**DELEGATED DECISION FOR APPLICATION FOR CERTIFICATE OF
LAWFUL DEVELOPMENT**

Reference no.: 2026/CL/91427/W

Site: 14, Lincroft Avenue, Dalton, Huddersfield, HD5
8DS

Description: Certificate of lawfulness for proposed installation of
velux windows to front and rear with rear dormer and associated alterations

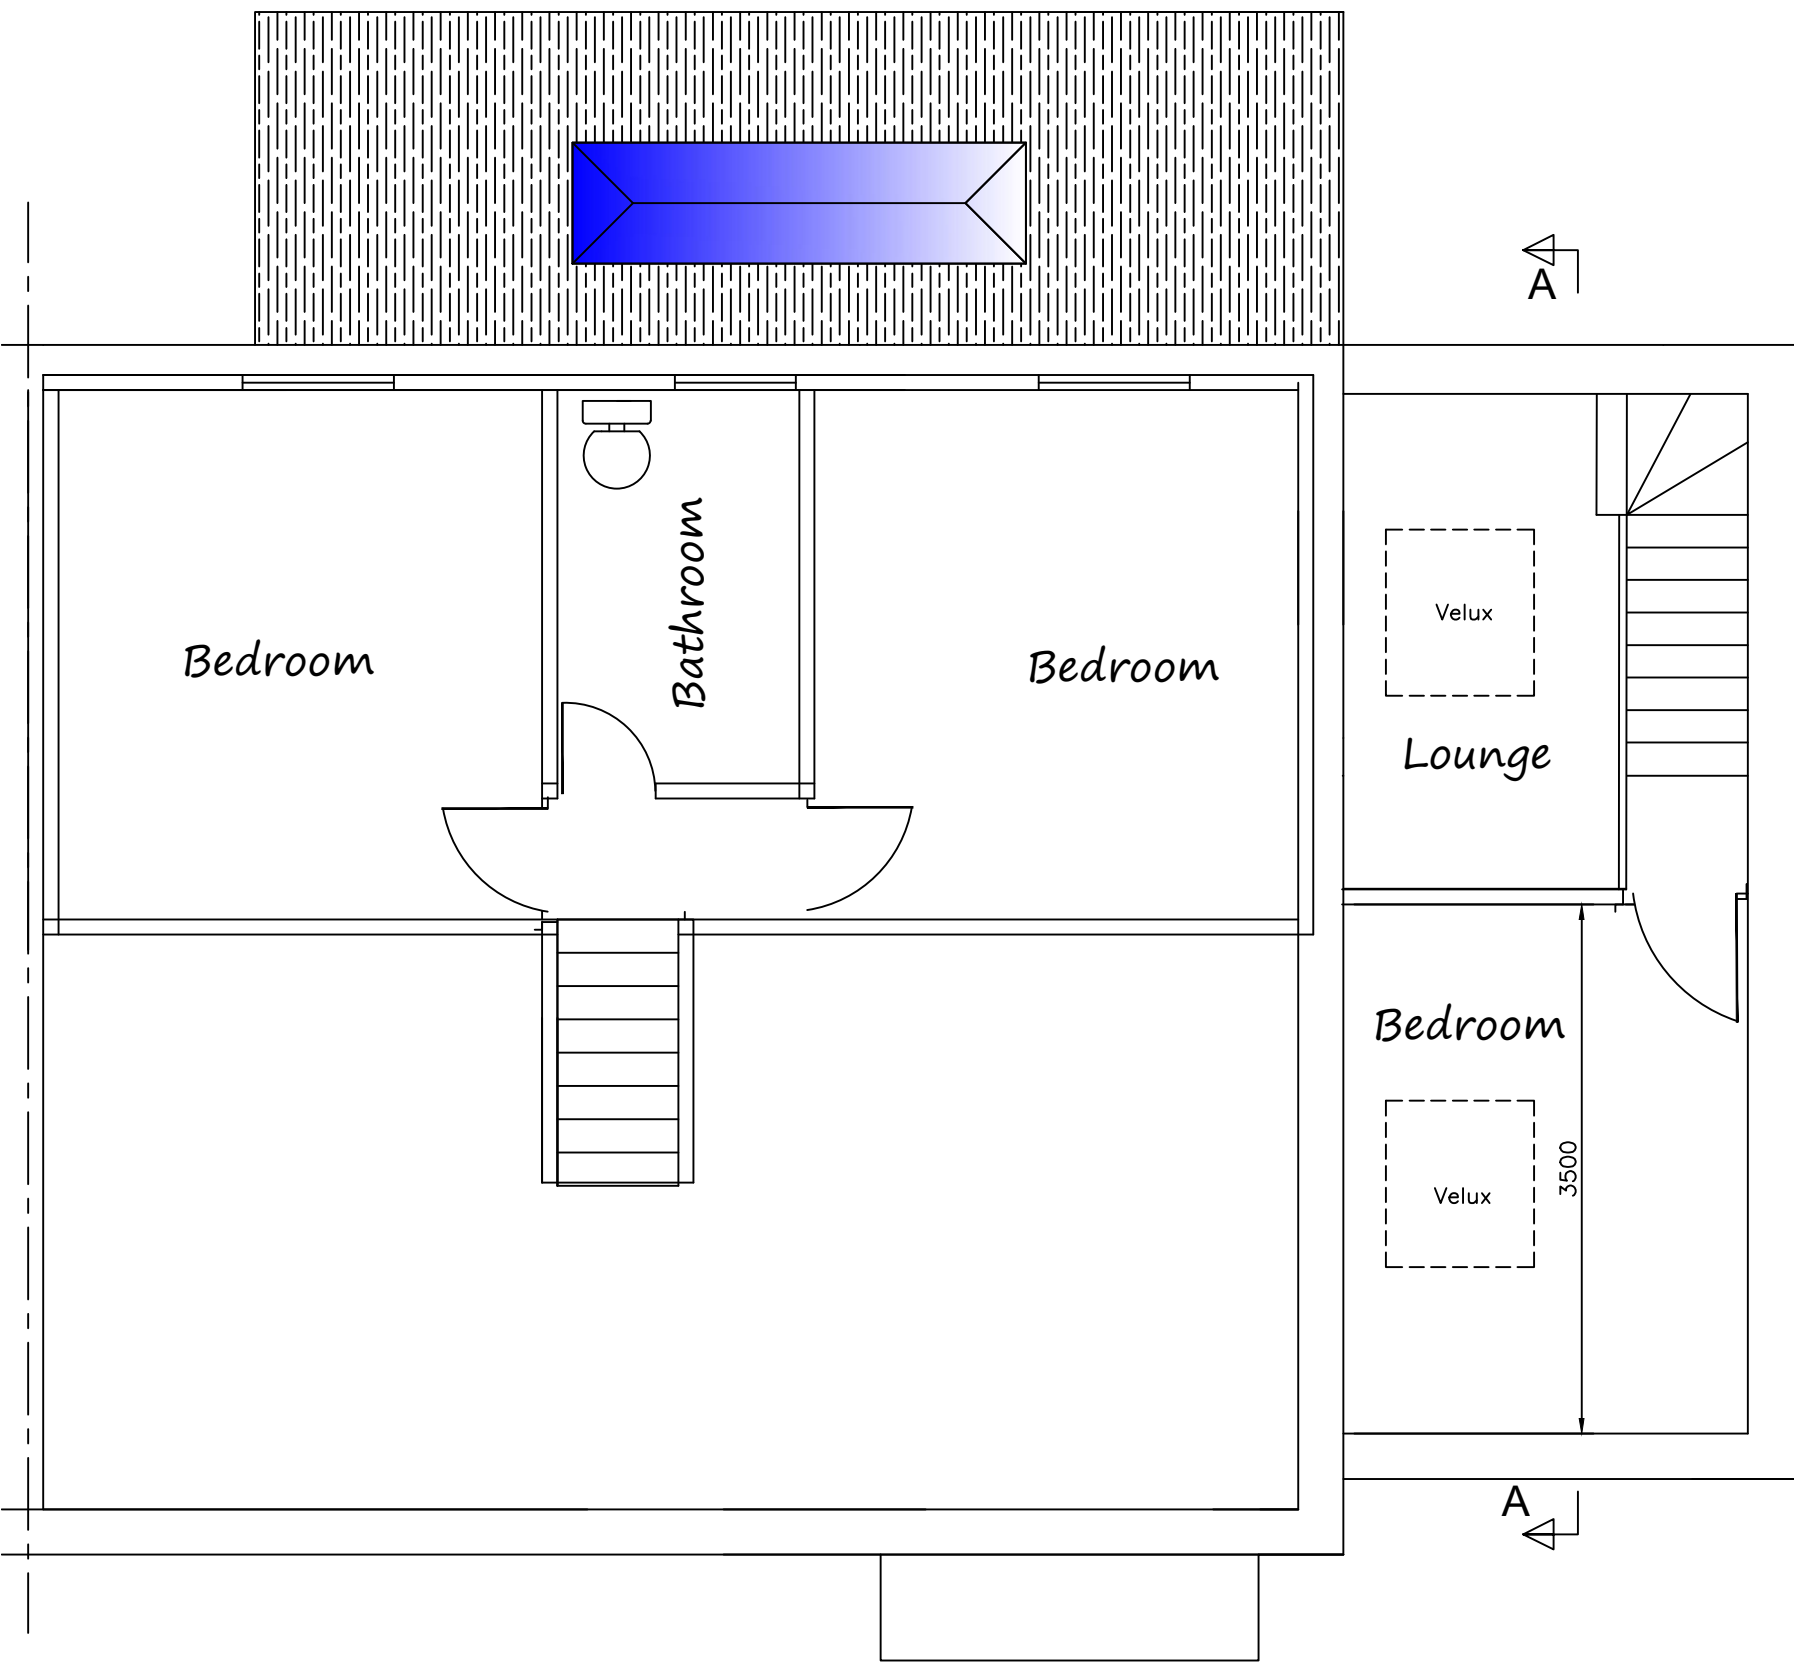
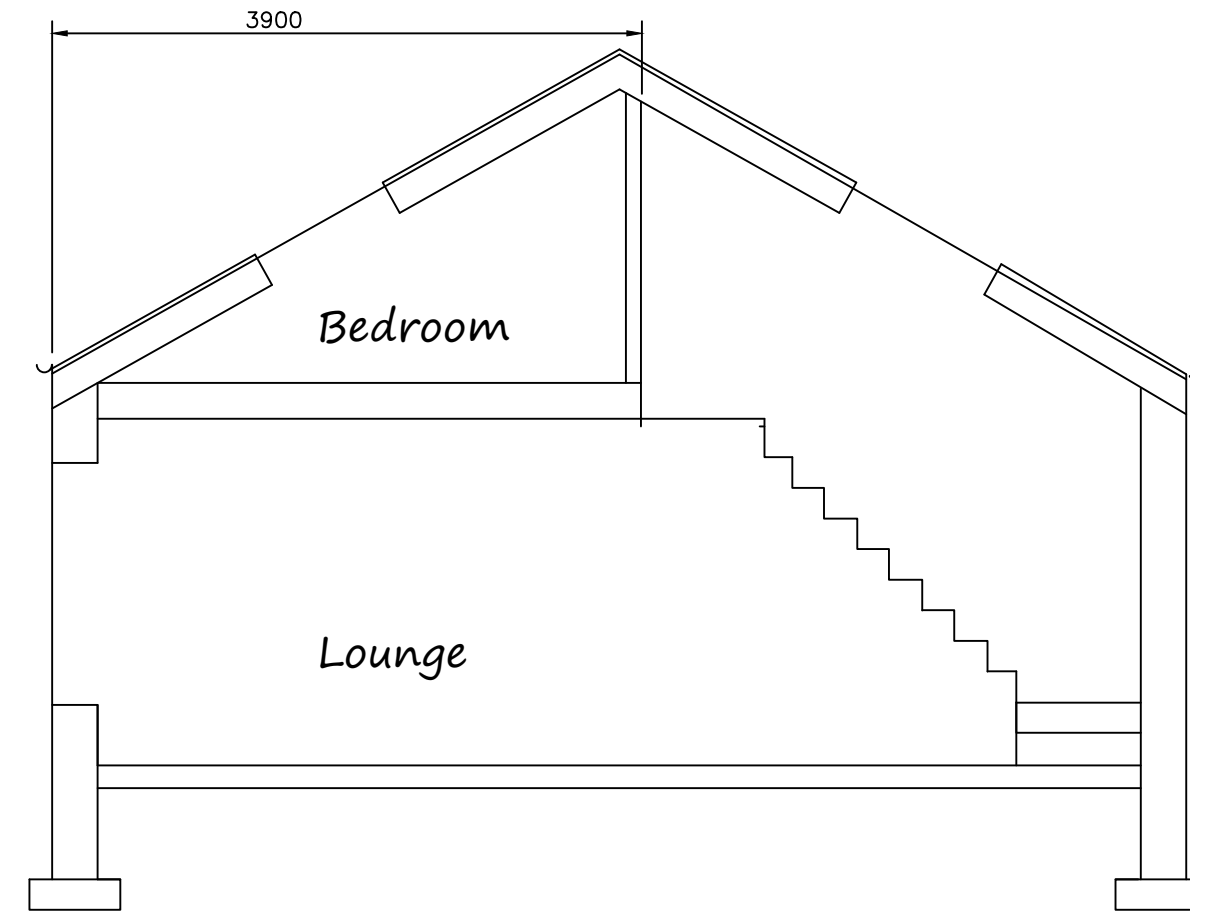
The dormer is on rear elevation, set back from the existing eaves by approximately 0.2 metres being a width of 8.4 metres. The dormer would project 3.55 metres from the roof ridge and would be a total height of 2 metres. The total cubic volume increase would be approximately 29.8cm³.

The submitted plans are annotated with the cubic volume of the side extension roof form. However, only half of the roof volume has been calculated and not the full roof volume. It appears that the space that has been calculated only factors in the accommodation within the roof space and not the total roof increase.

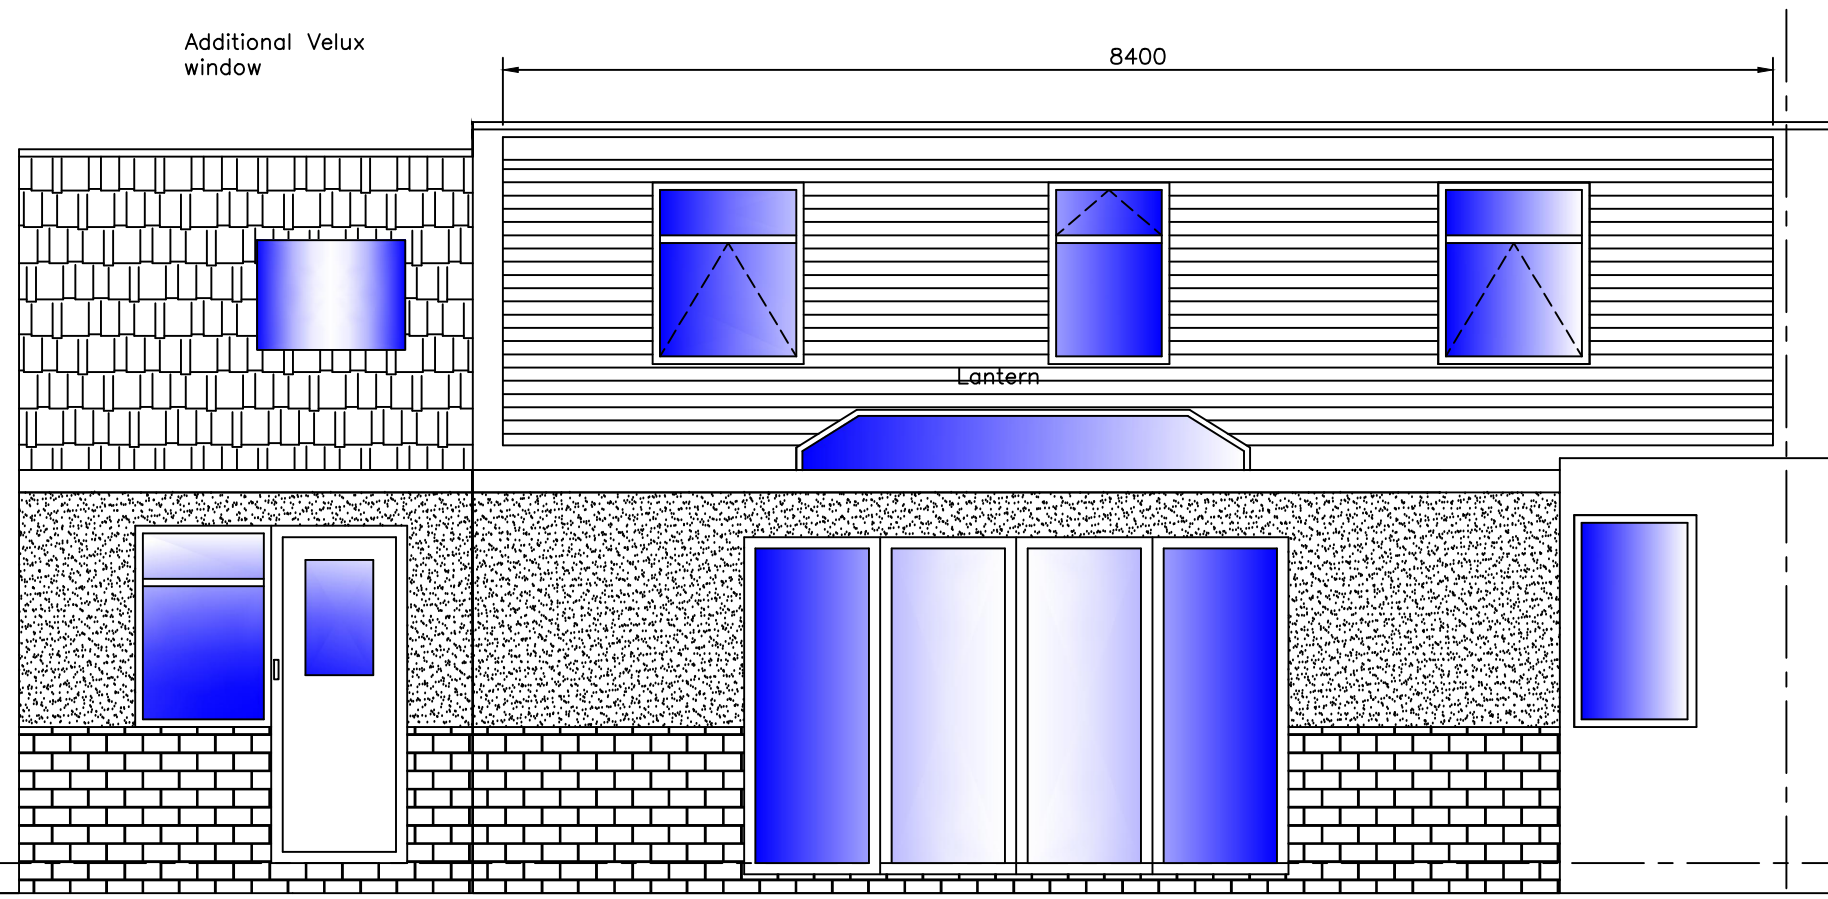
The velux roof lights would be located within the front and rear elevations of the side extension.

Comment: *The submitted details do not indicate that the roof lights protrude more than 0.15 metres beyond the roof plane*

Comment: *The height of the rooflights would not be higher than the highest part of the original roof.*

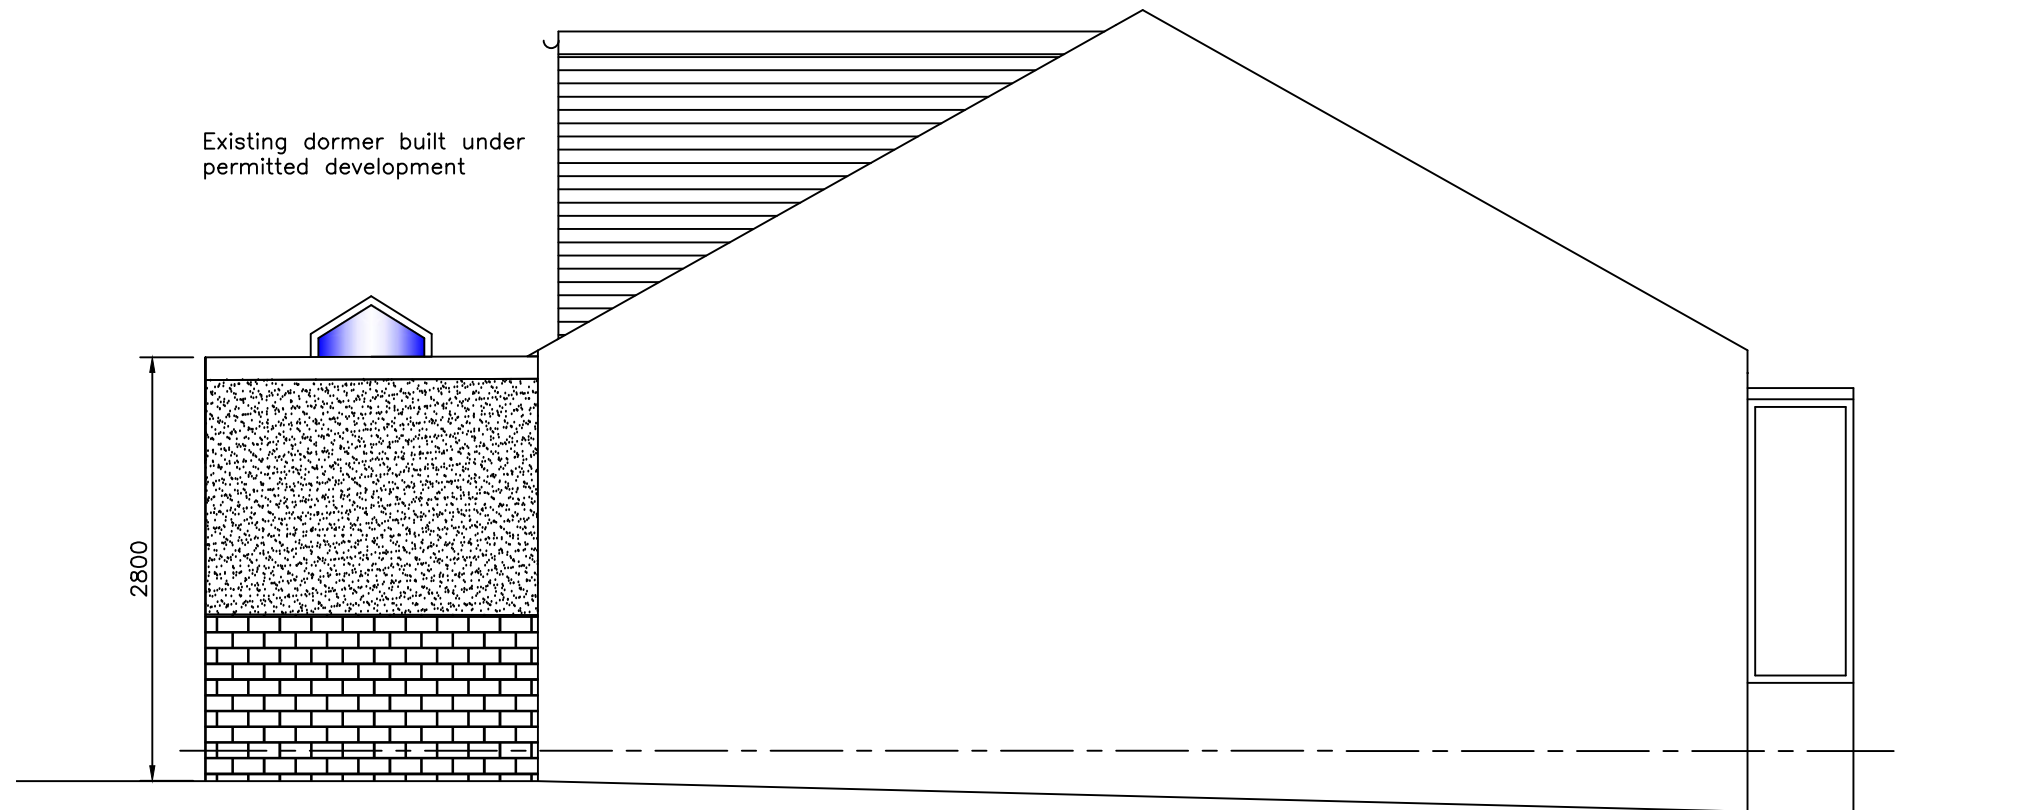
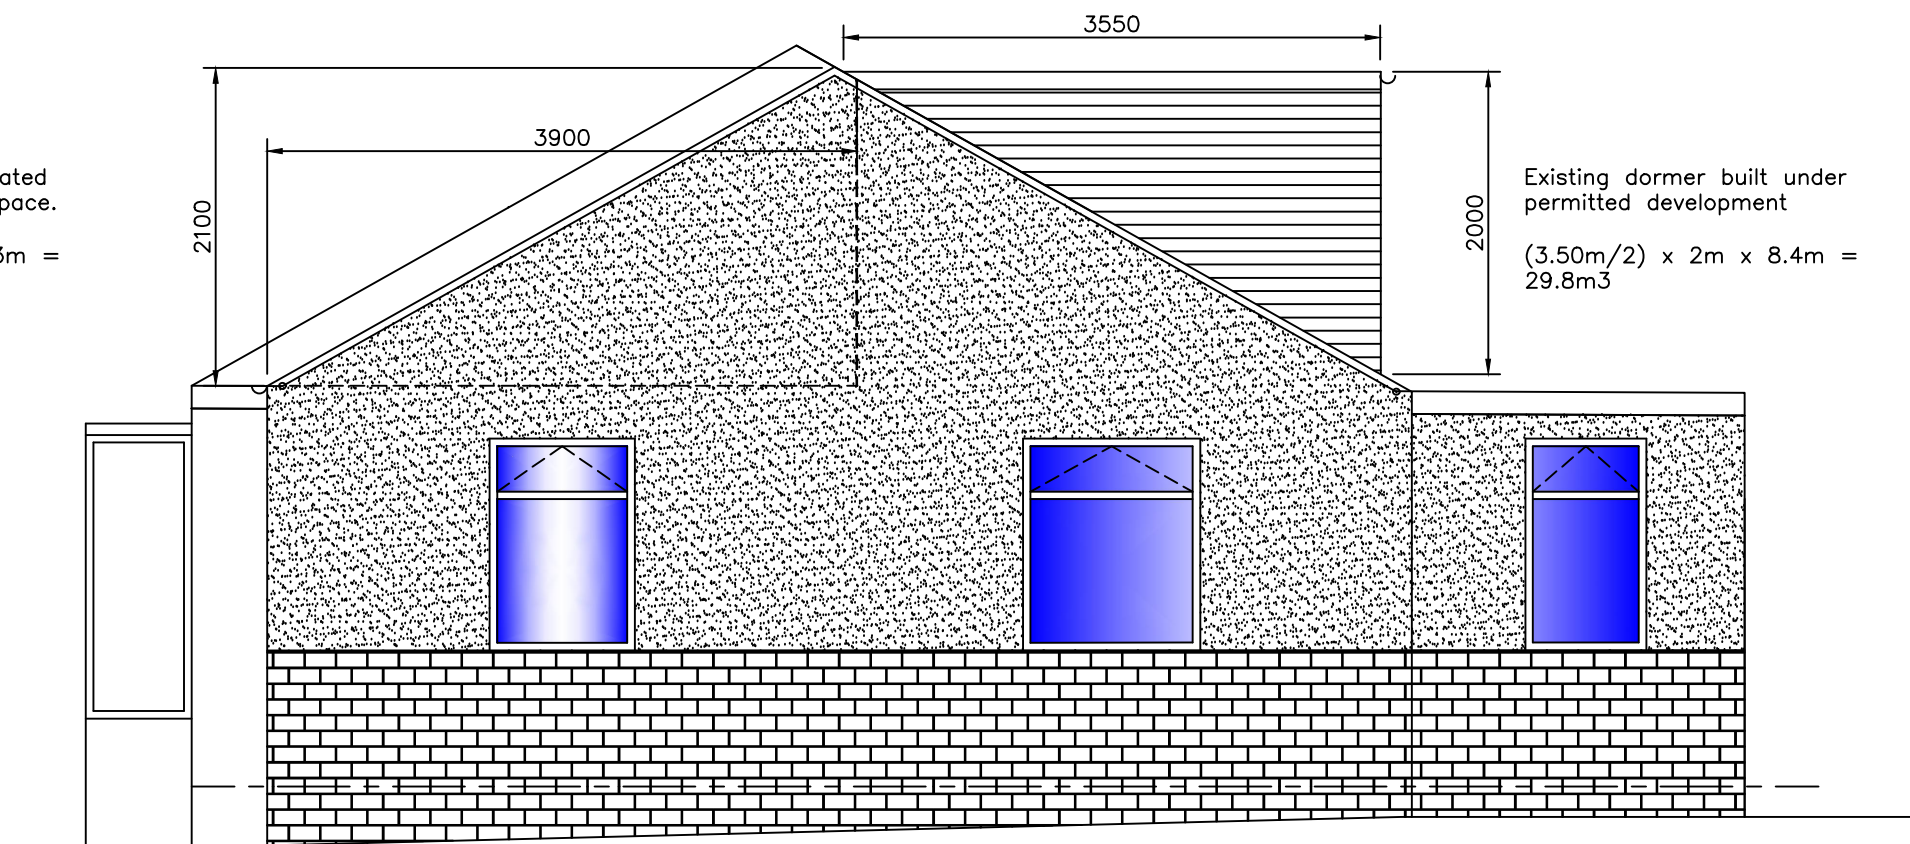
Comment: *The detail contained within the application submission include the rear dormer and half of the roof form of the side extension where the accommodation is situated, which equates to approximately 43 square metres. The requirement of this paragraph is the resulting roof space and therefore the entire roof form of the side extension should be considered as part of the calculation. The dimensions of the side extension roof are 3m x 7.5m x 2m /2 which equate to 22.5m³. Therefore, when calculated with the dormer which has an increase of 29.82m³ the total increase in roof volume is over the 50m³ prescribed.*

The enlargement to the roof (dormer) has been assessed against the relevant legislation, Town and Country Planning (General Permitted Development) (England) Order 2015 (as amended), Schedule 2 Part 1, Class B and it has not been deemed permitted development. This is due to the cumulative volume of the dormer and the side extension roof resulting in more than 50m³ of roof space being created.
